DECISION DELEGATED TO HEAD OF PLANNING

Application No: H20-0293-25 **Applicant:** Mr B Roffe
Proposal: Demolition of existing barn & erection of one dwelling & garage
Location: Ivy House Farm Sutton Road Sutton St James
Terminal Date: 8th August 2025

Drawing
FLOOR PLAN - PROPOSED

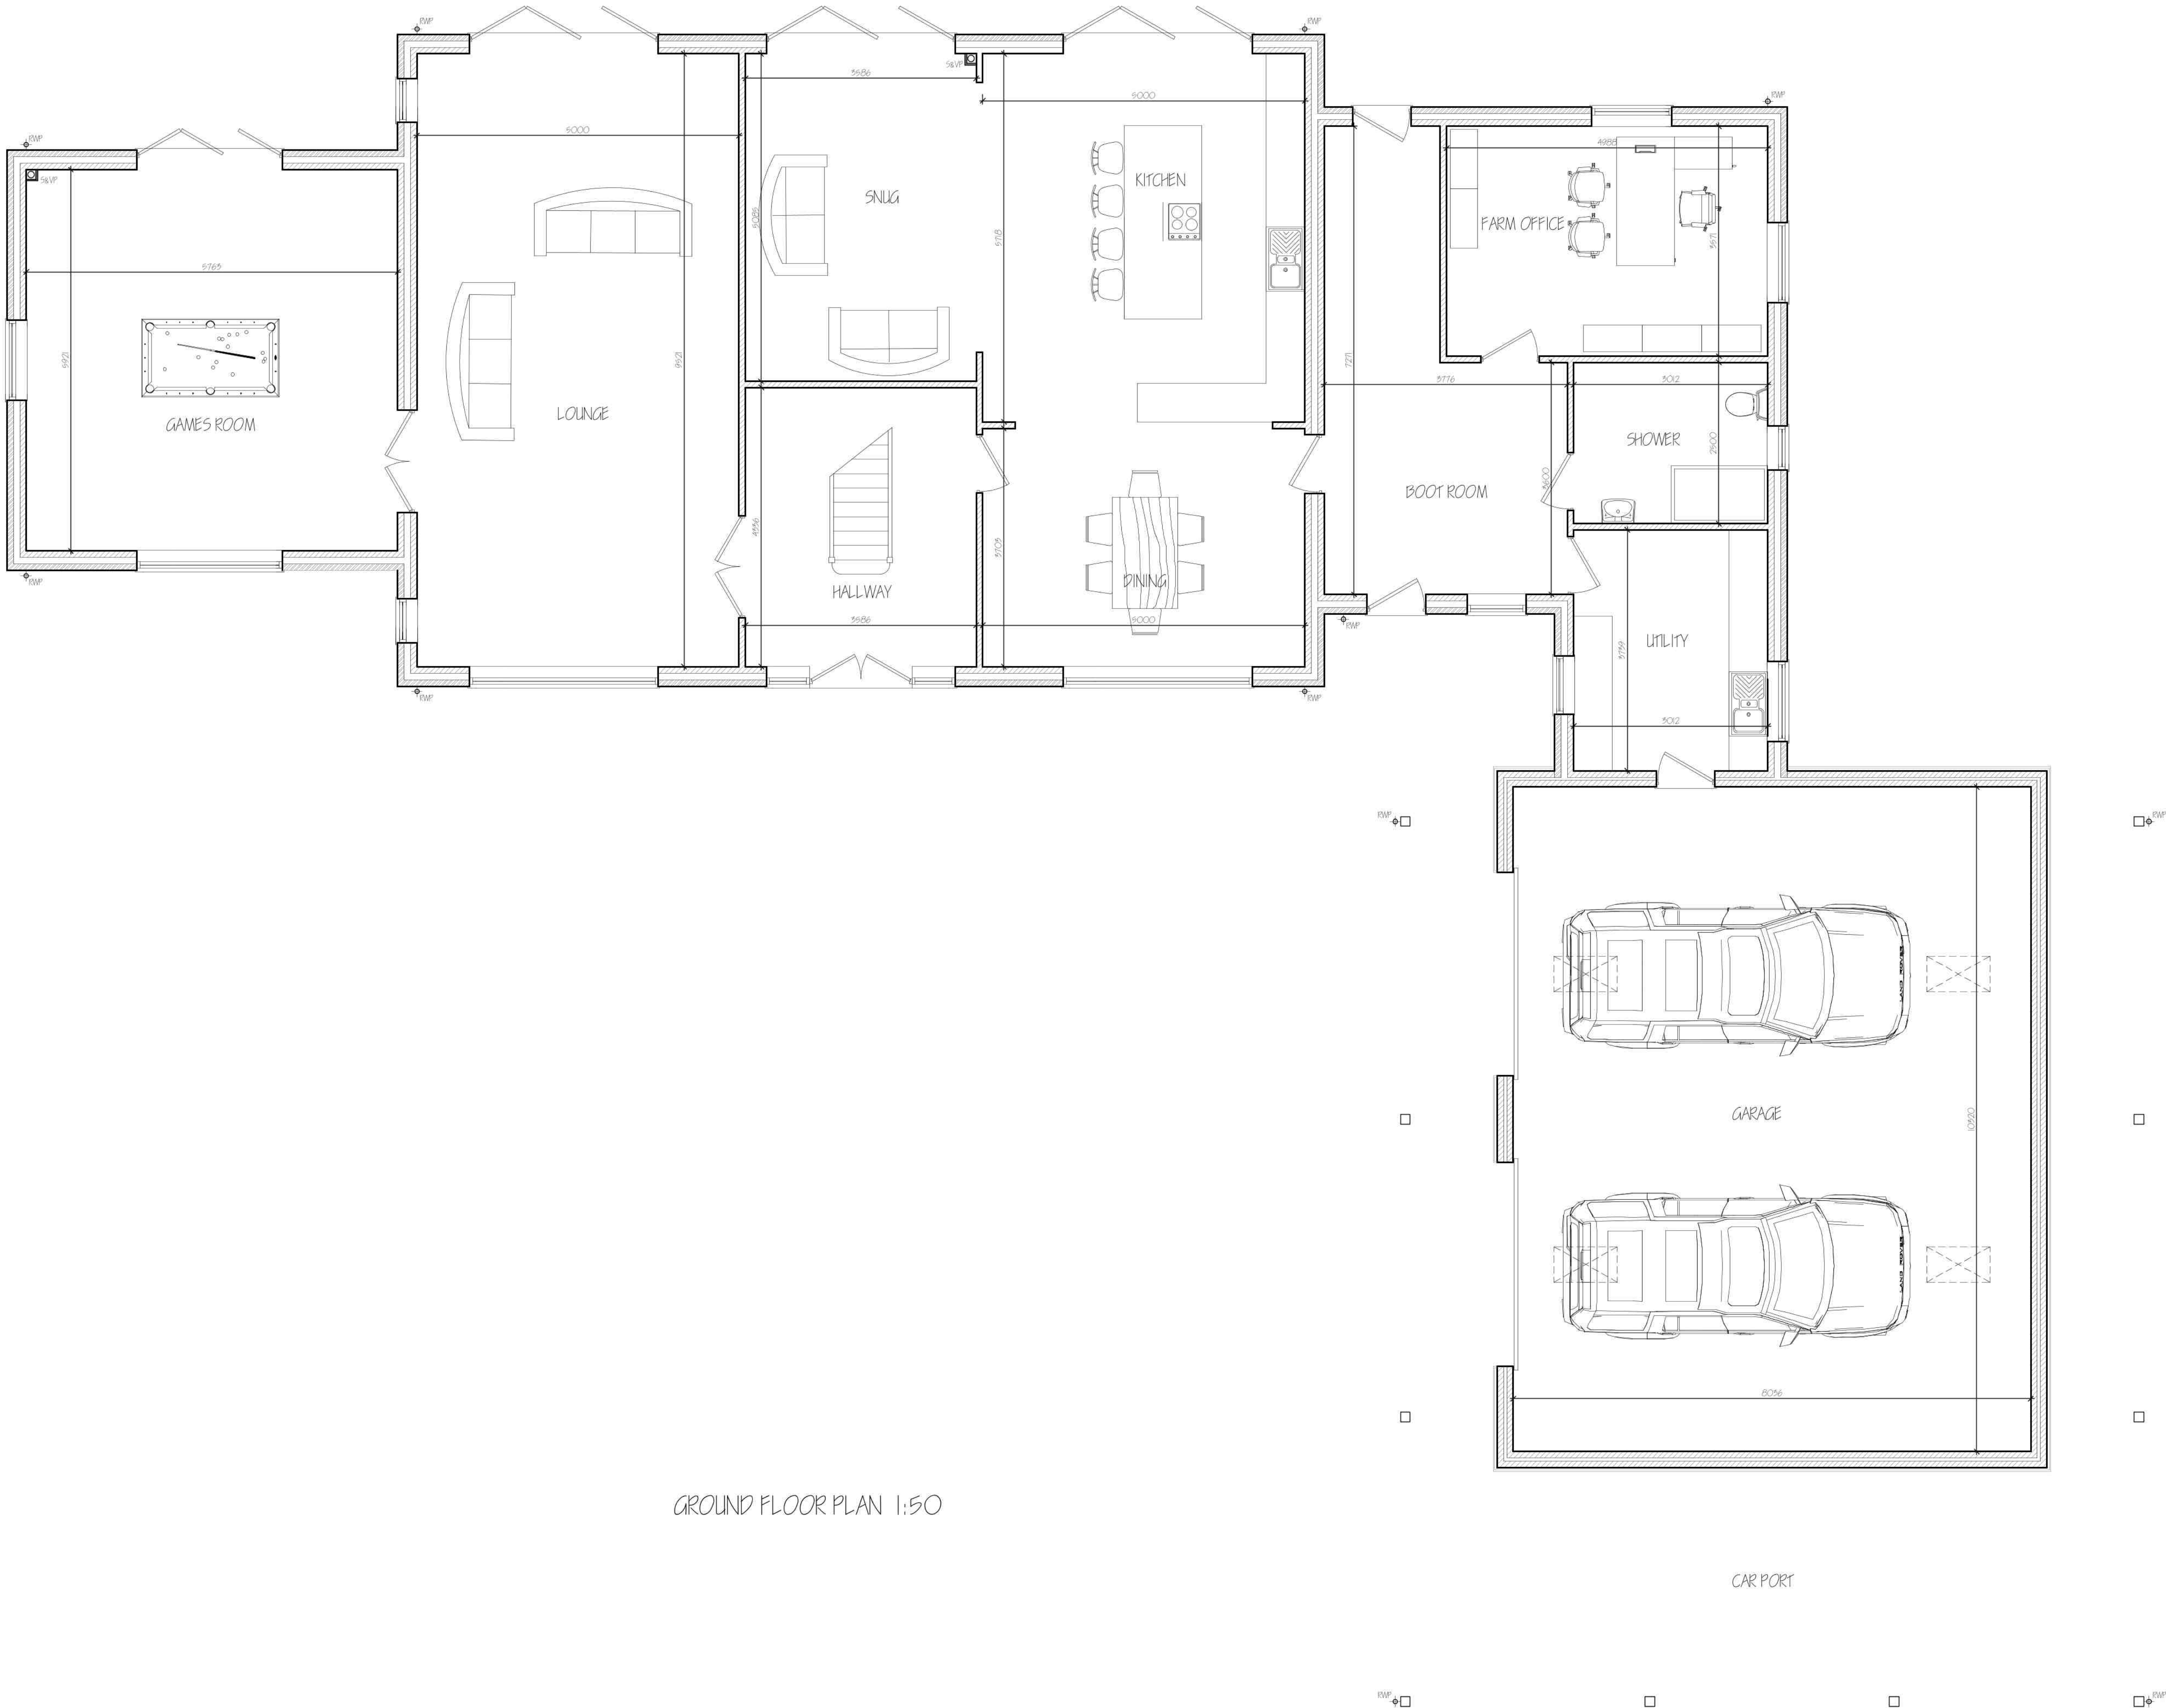
The proposed design of the dwelling is considered to be disjointed due to the various sections of the dwelling, multiple roof heights and different roof forms. The Design and Access Statement does not

The application seeks consent for a detached dwelling and garage. The main part of the dwelling features three sections, each with a gable end roof form and each section is a different height. The main part of the dwelling measures approximately 27m in length and 10m in width at its widest. The different parts of the dwelling measure 7m, 9.3m and 5.8m in height.

The garage is proposed to be located in front of and to the side of the main dwelling. The garage features a jerkinhead roof form and the structure is proposed to be connected to the main dwelling with a smaller extension featuring a gable end roof form. The garage is proposed to measure 6.7m in height up to its ridge line.

As set out above, the multiple sections of the dwelling, and various roof forms result in a disjointed design that does not respond positively or sympathetically to the character or appearance of the area. The site is within a relatively rural area and the site itself is set within open flat land. The proposed built form and the large residential curtilage would have a detrimental impact on the character and appearance of the area. The proposed built form of the dwelling and attached garage would comprise nearly double the built form of the approved barn conversion that was permitted under permission H20-0833-24. Whilst the suitability of a design is not only based on the quantitative built form, this further underlines the inappropriate nature of the proposal.
